**From:** Anita Gardner <[anita.gardner@arun.gov.uk](mailto:anita.gardner@arun.gov.uk)>  
**Sent:** 04 June 2020 16:38  
**To:** Planning.Responses <[planning.responses@arun.gov.uk](mailto:planning.responses@arun.gov.uk)>  
**Subject:** FW: M/37/20/NMA - Little Thatch, Middleton Road

Attention Mrs A Gardner  
Re 93 Middleton Road NMA No2

I have amended drg 103A Proposed Ground Floor and Elevations with the changes you requested. It is attached as a PDF using the same conversion process I adopted for the original application.

Sheet 3

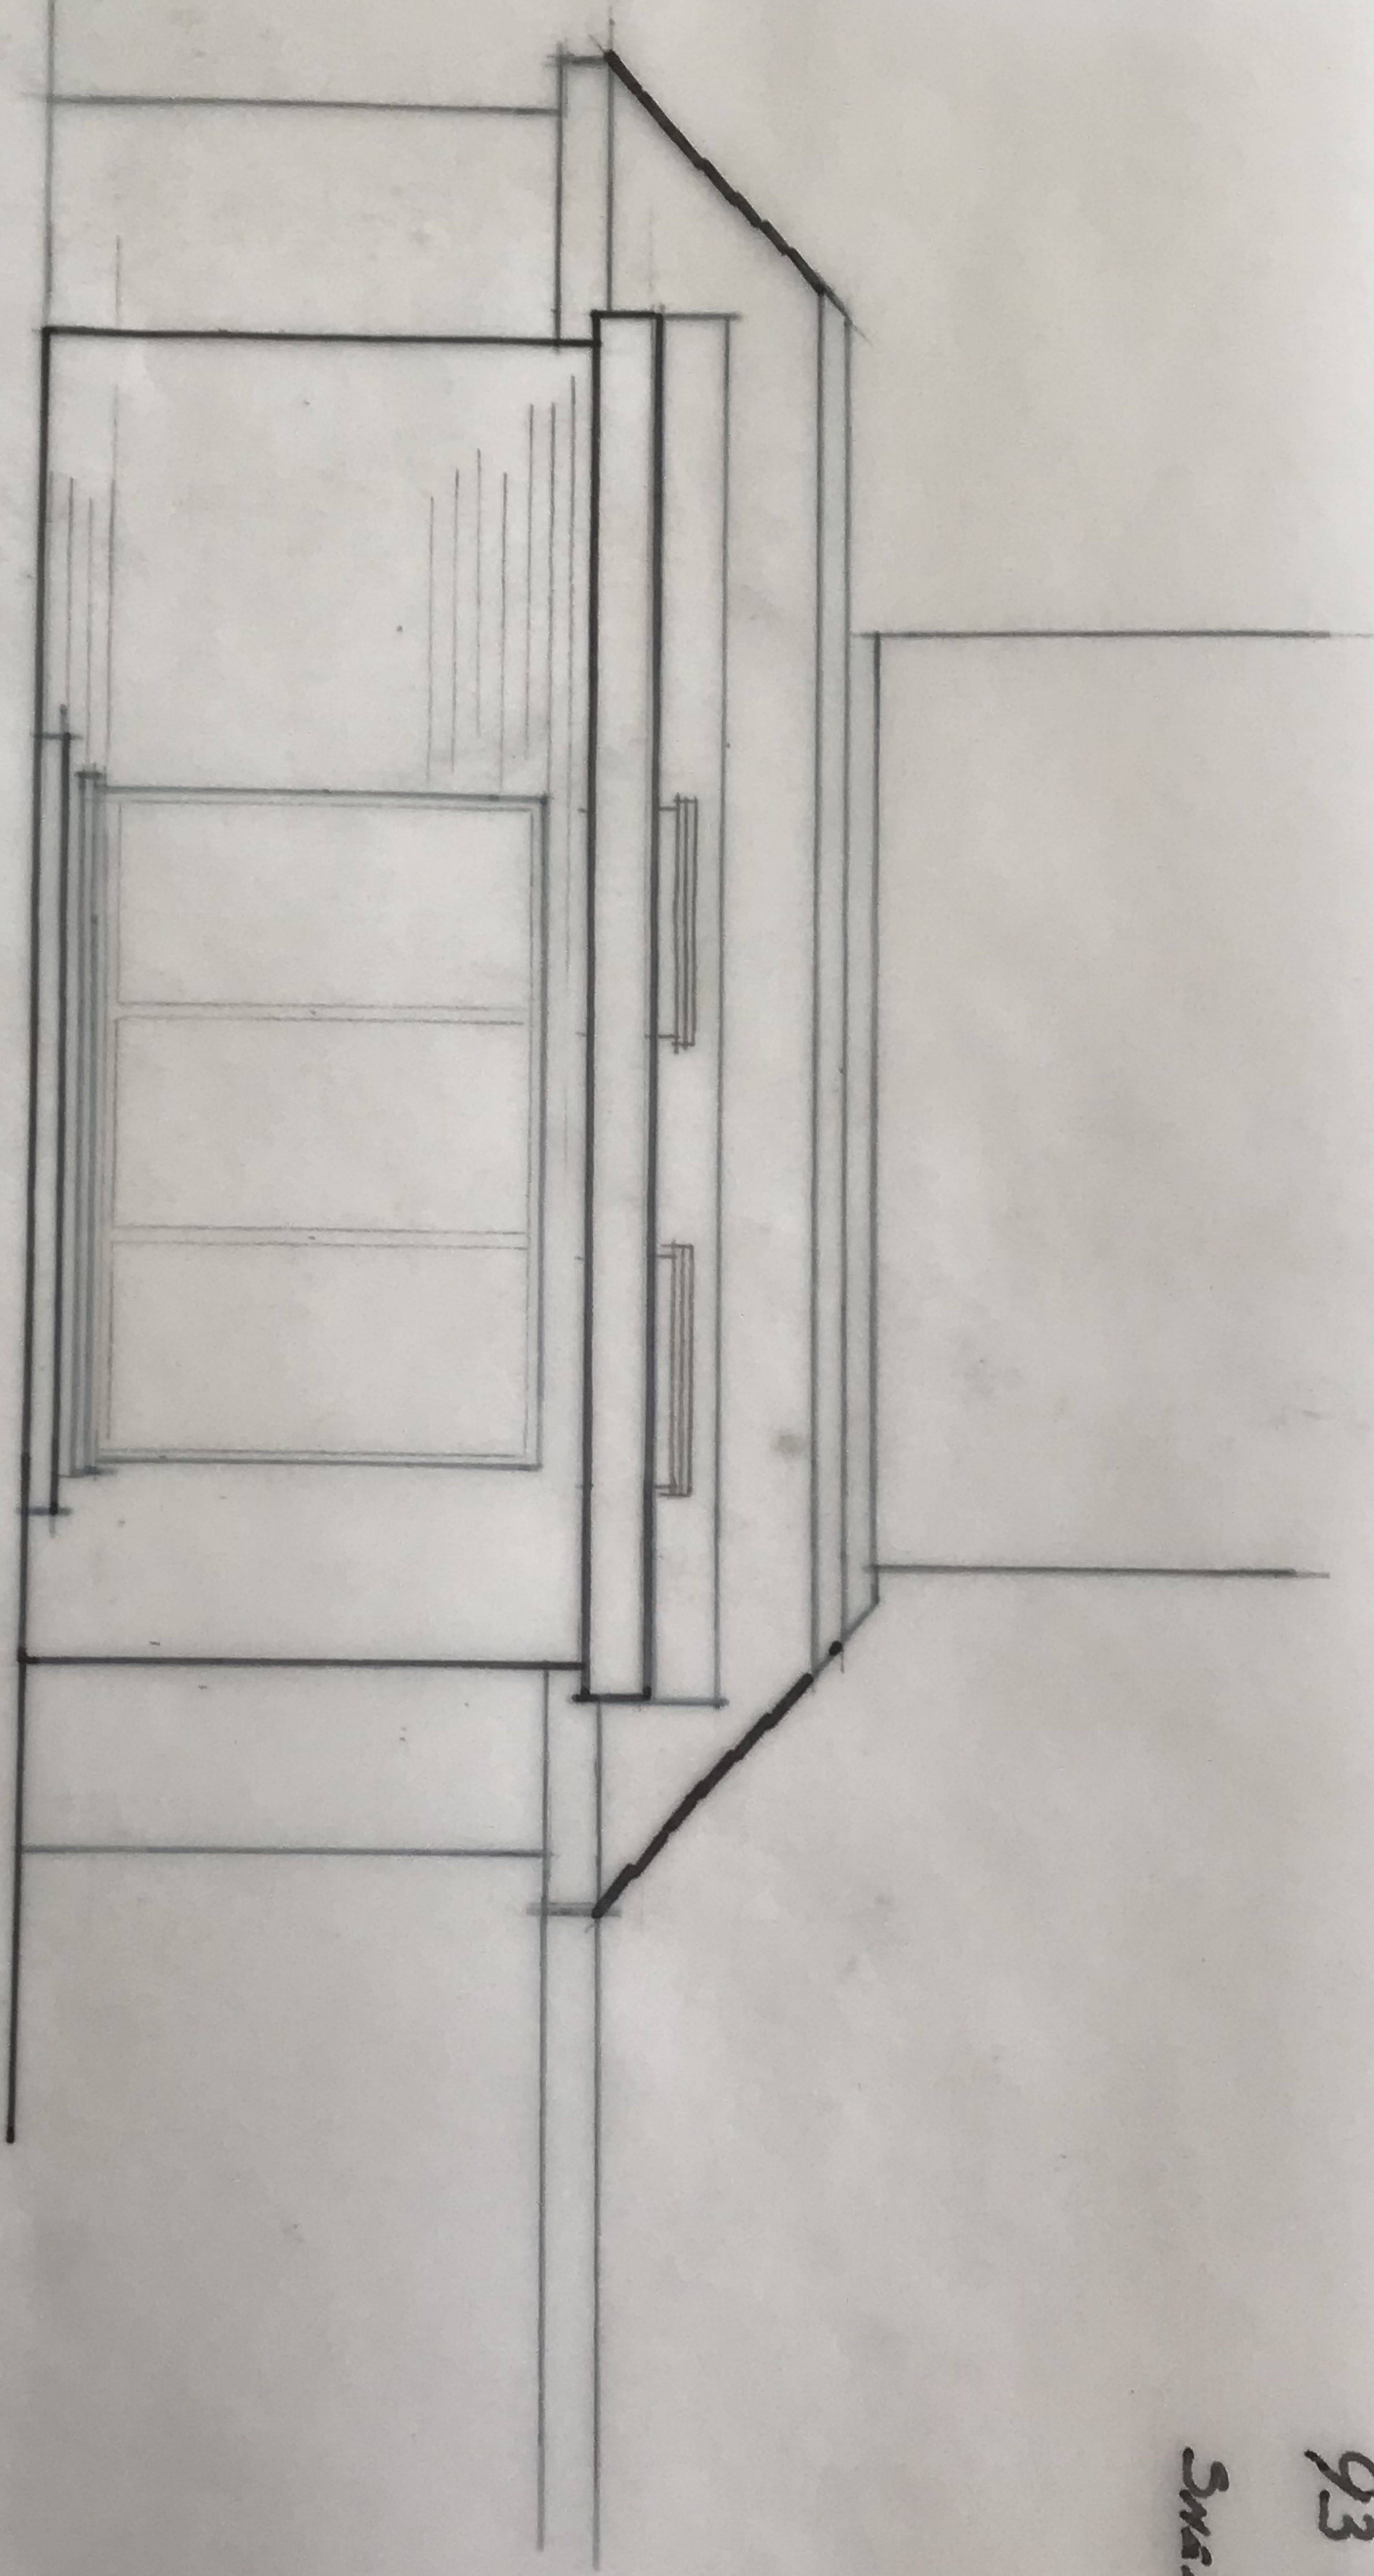
I've started looking at the above application to assess if I can accept it as an NMA, but I can't scale the following 3 plans : Section, Sheet 2 West Elevation or Sheet 3 North Elevation which don't have a scale, although there are some measurements given. The only plans which have a scale don't have a measure tool bar appearing so that I can scale them electronically. I would therefore appreciate floor plans and elevations of the existing and proposed conservatory so that any differences are clear and dimensioned.

DRAWING 103 B.

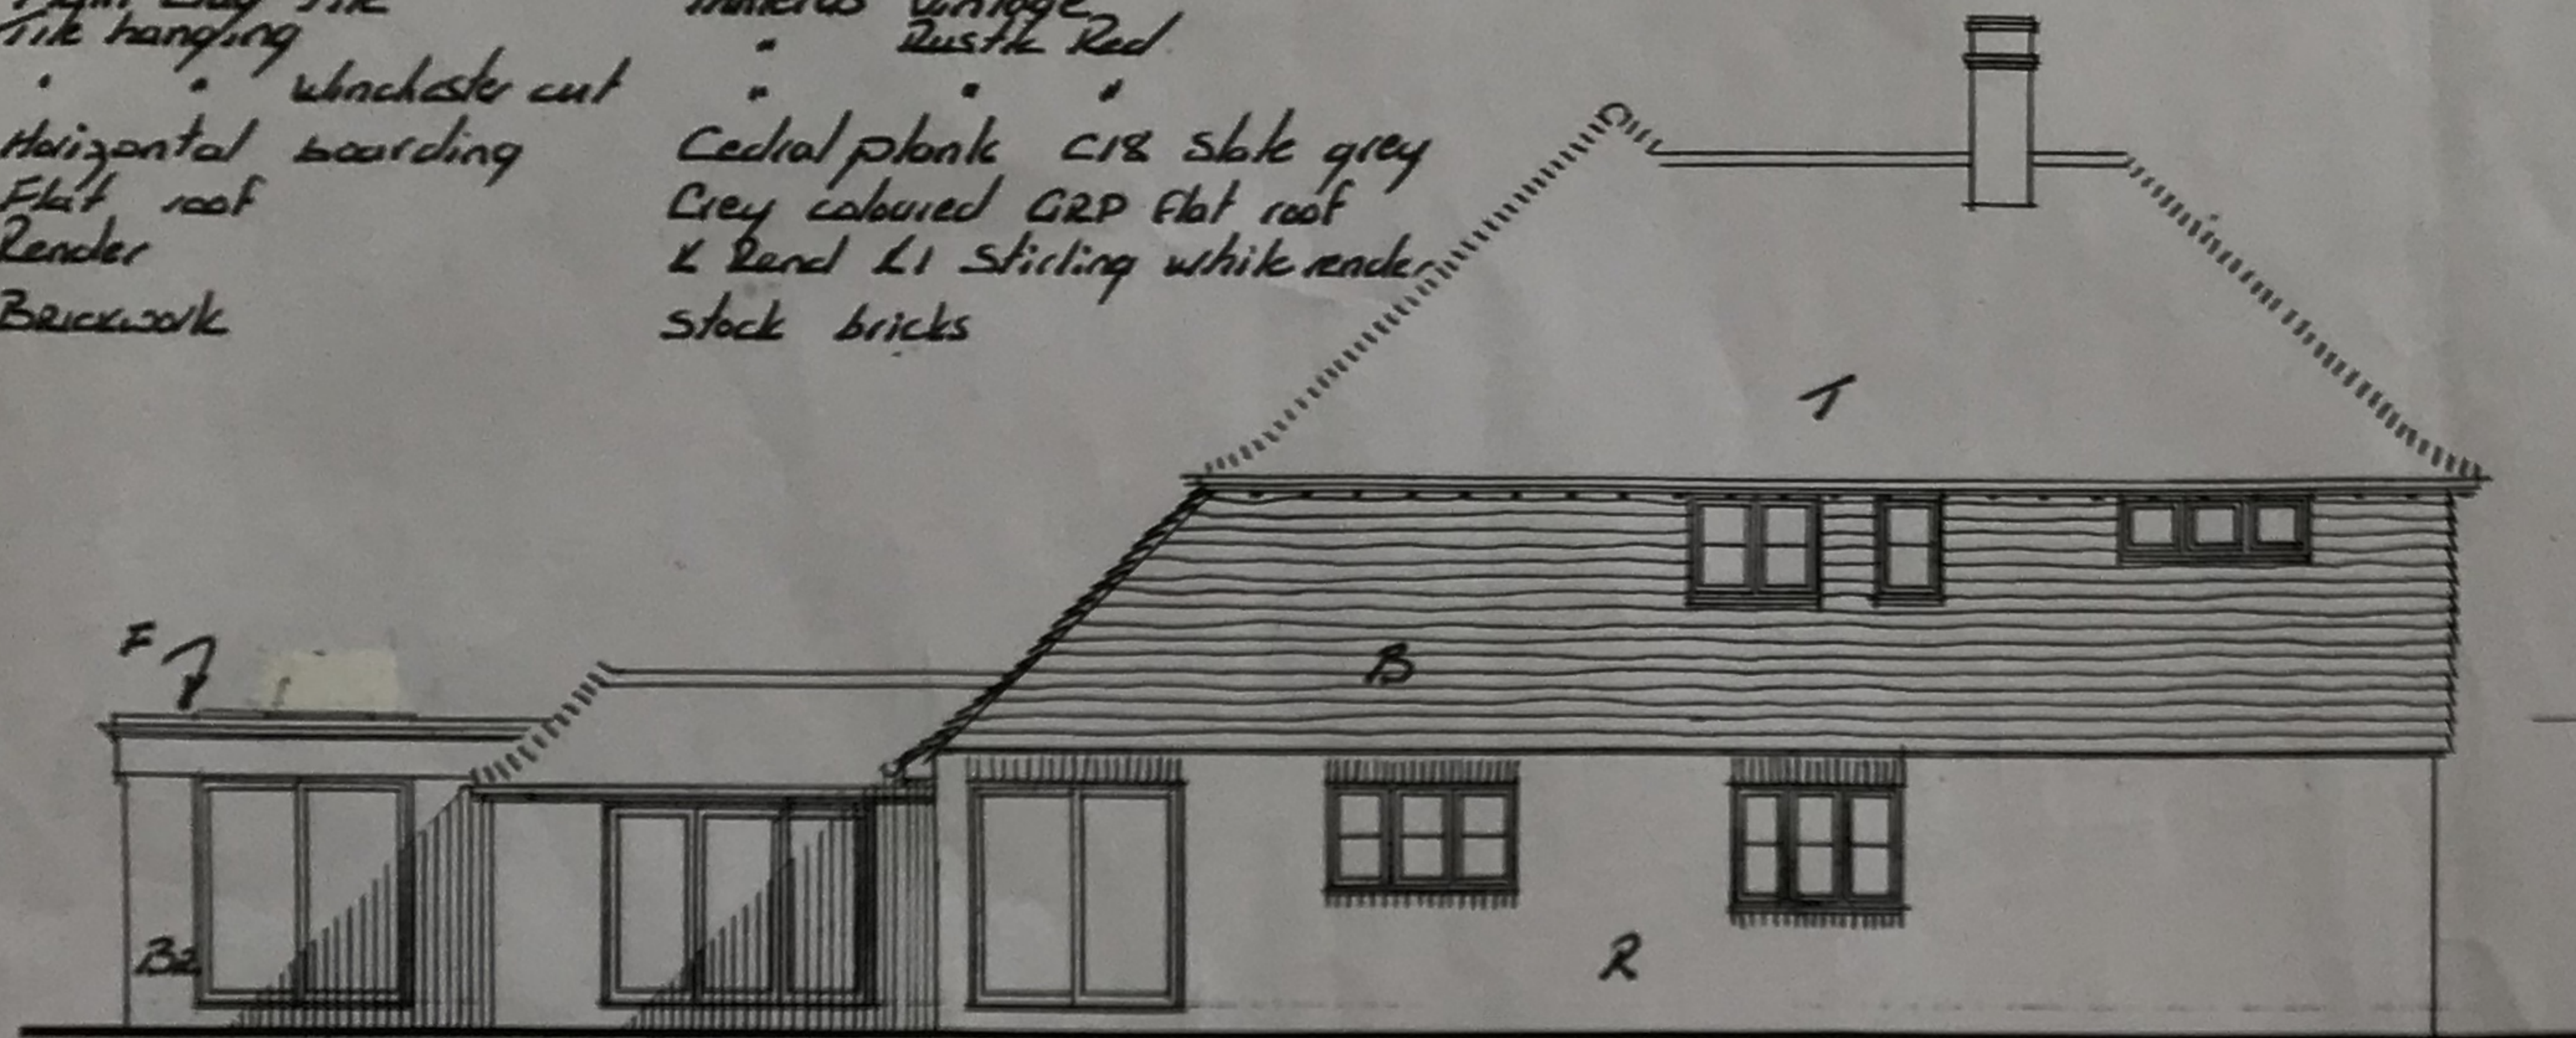
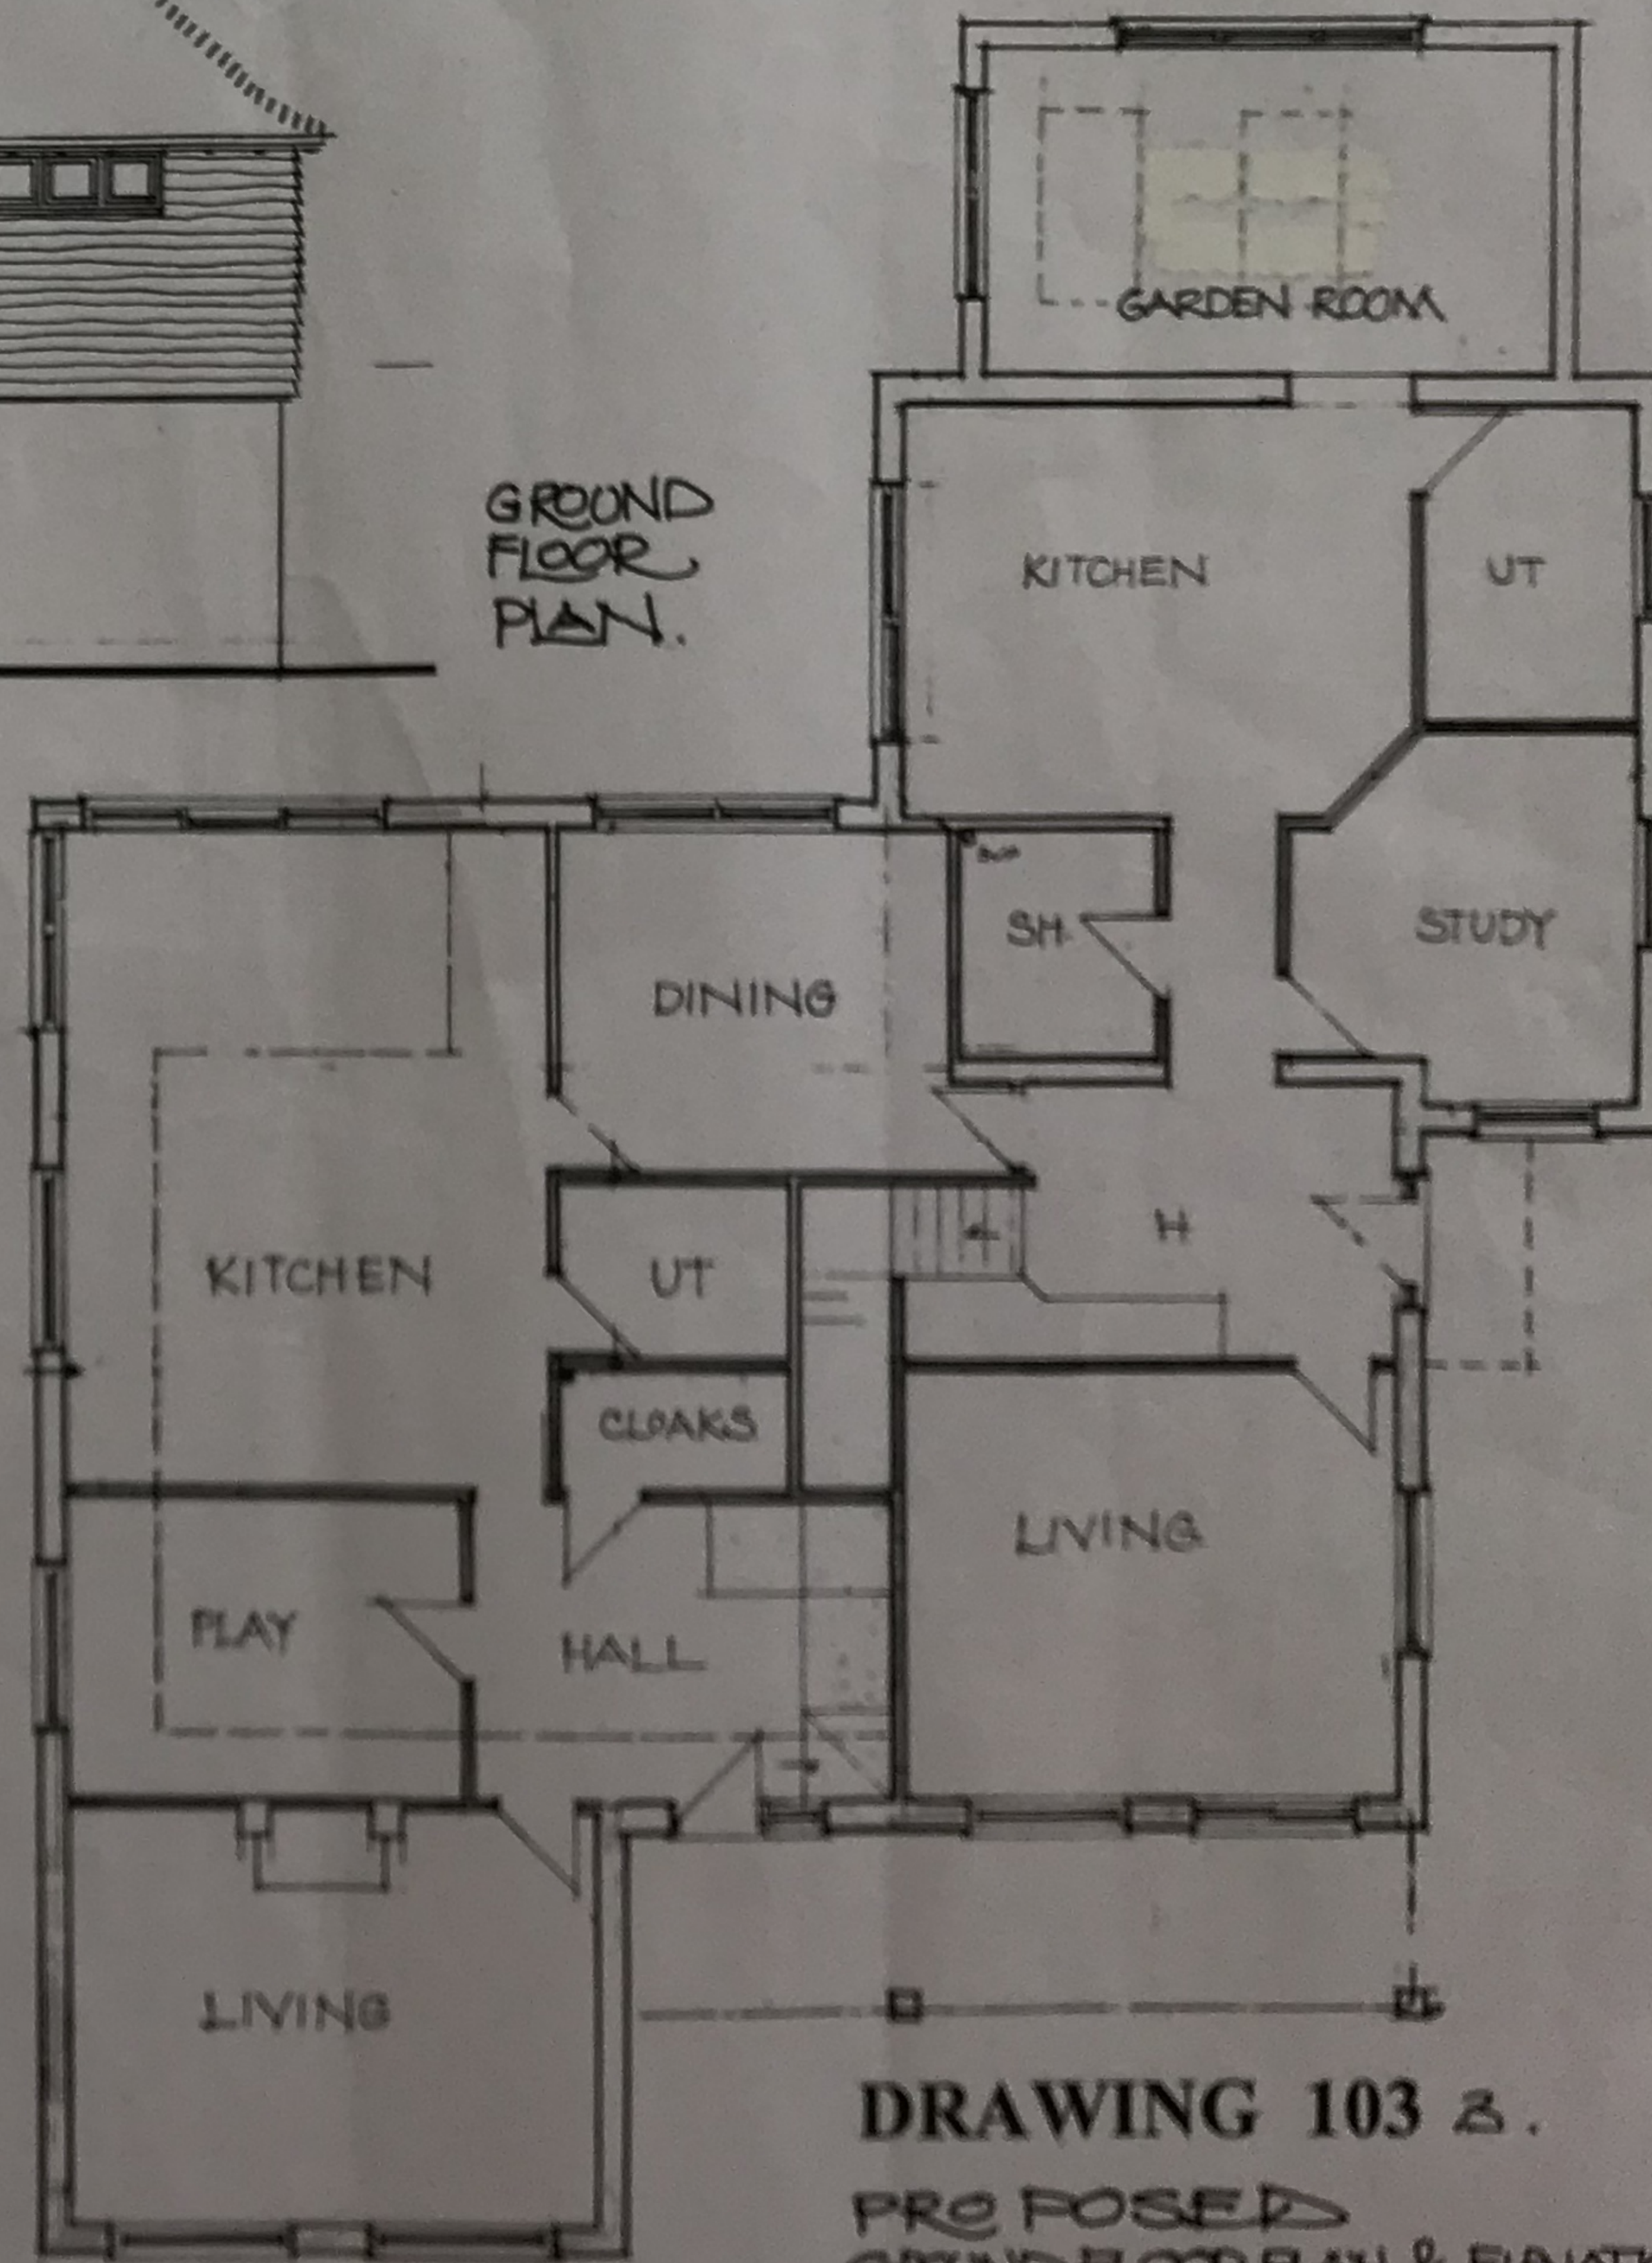
If the change in materials to the main house is to remain included in the application I will need an amended version of the original drawing number 15.05.2018 Proposed ground floor plan and elevations 103 A which was approved under M/133/17/PL so that the approved materials schedule on that plan is effectively superseded and you could also include the changes to the garden room/conservatory on that plan. I am happy to await receipt within the next week to progress all of the amendments sought together in a single NMA application.

Have amended the materials schedule showing the Cedar Plank boarding to the main house and Brickwork to the Garden Room. Also, removed the Lantern Light from the plan and elevation and shown the proposed replacement skylights.

The drg is now 103B with the revised date and note of proposed changes.
